**From:** Rachel . <blparishclerk@outlook.com>  
**Sent:** 21 March 2023 14:08  
**To:** Planning  
**Subject:** Objection and concerns regarding 3/2023/0158

Consultation on planning application 3/2023/0158 Ribble Valley View Lodge Park, Old Langho Road, Langho BB6 8AW

Location Plan
Scale: 1:2500@A2

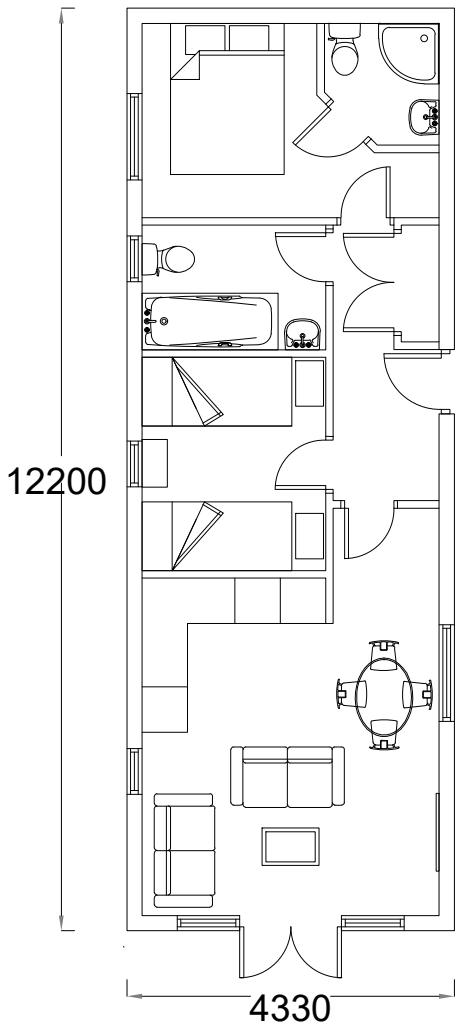
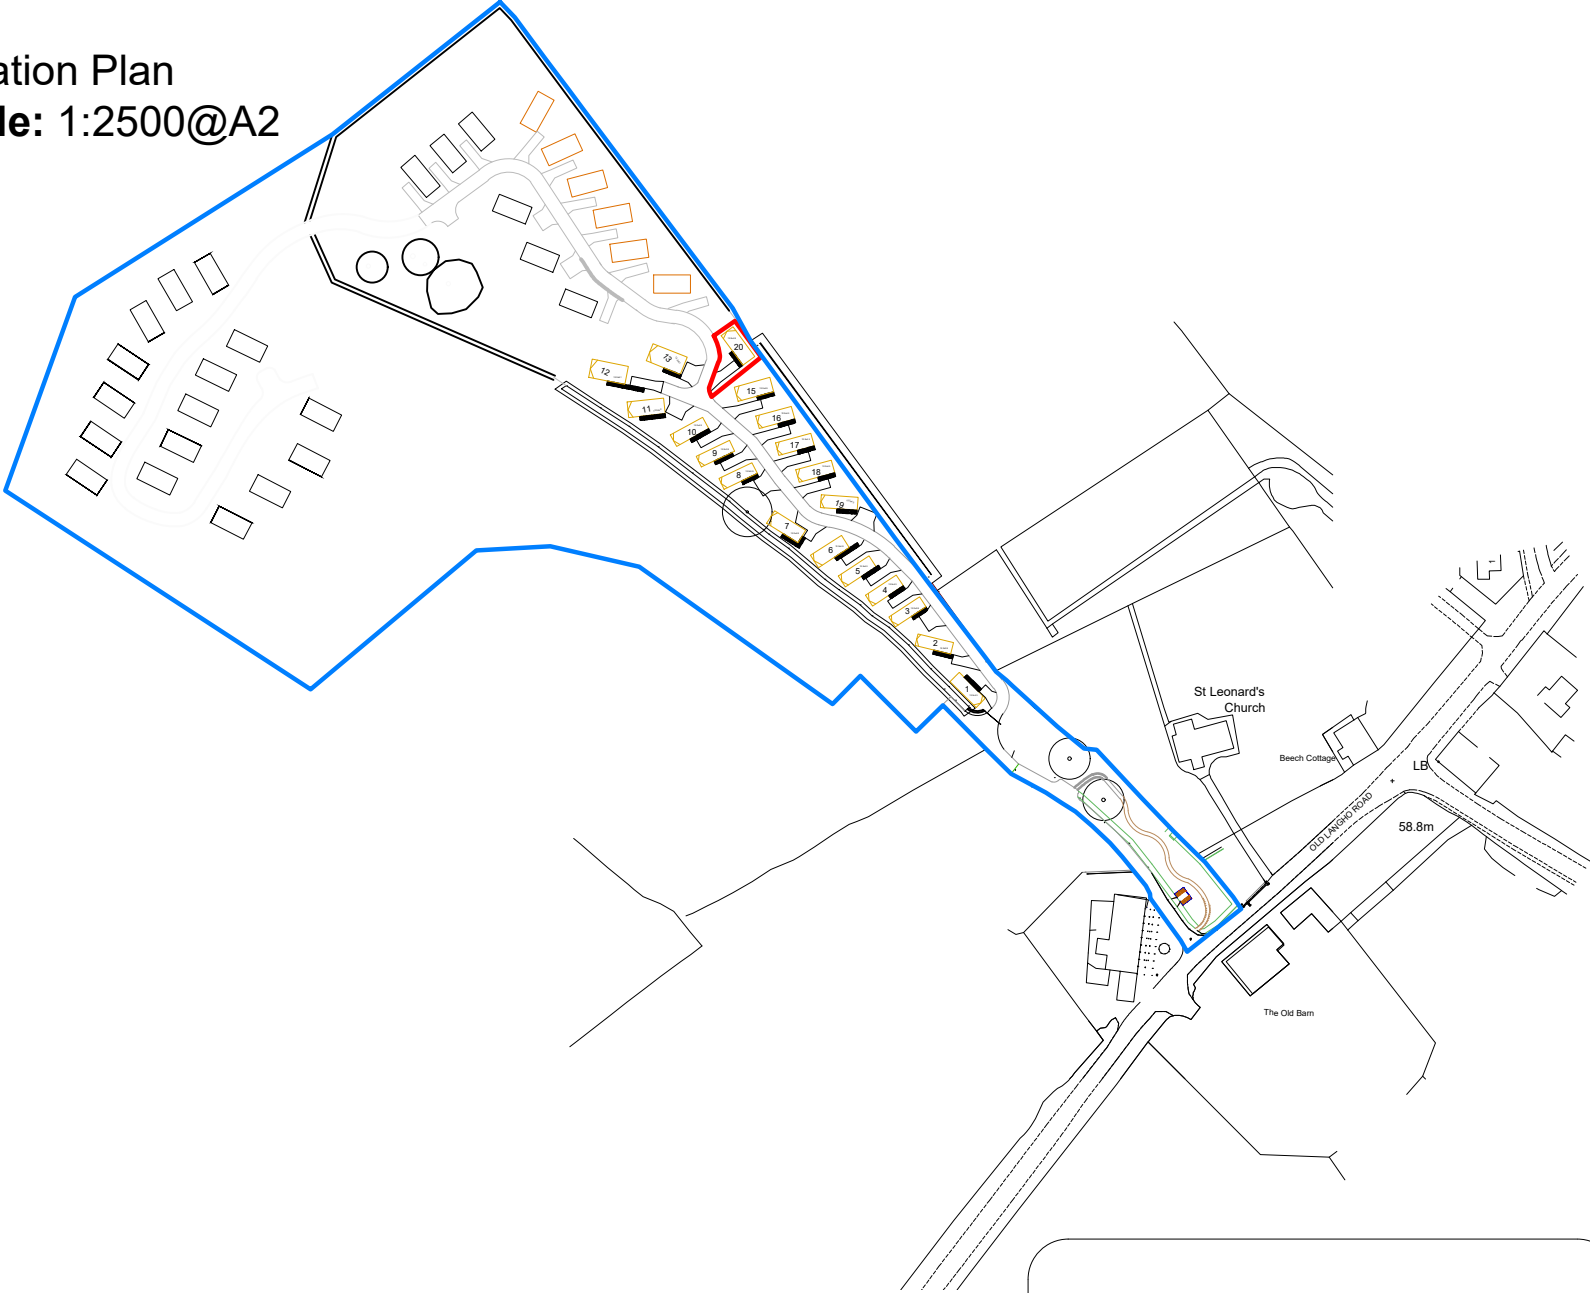
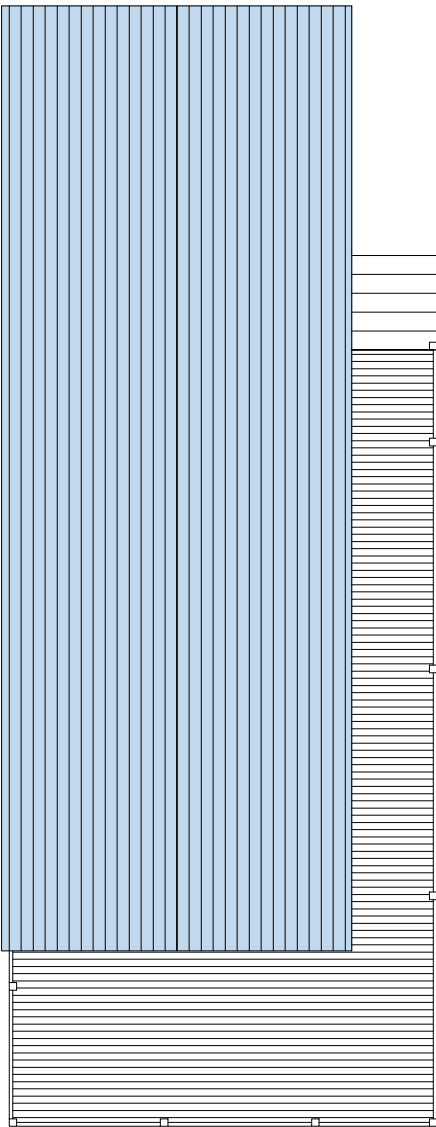
- Over development of the site. Concerns were expressed that this development would just keep expanding
- On the supplied drawing there is an area ringed with blue showing square boxes, will this be further developments?
- The application says the development cannot be seen from a foot path, this is not accurate and can this be checked by the planning team please.
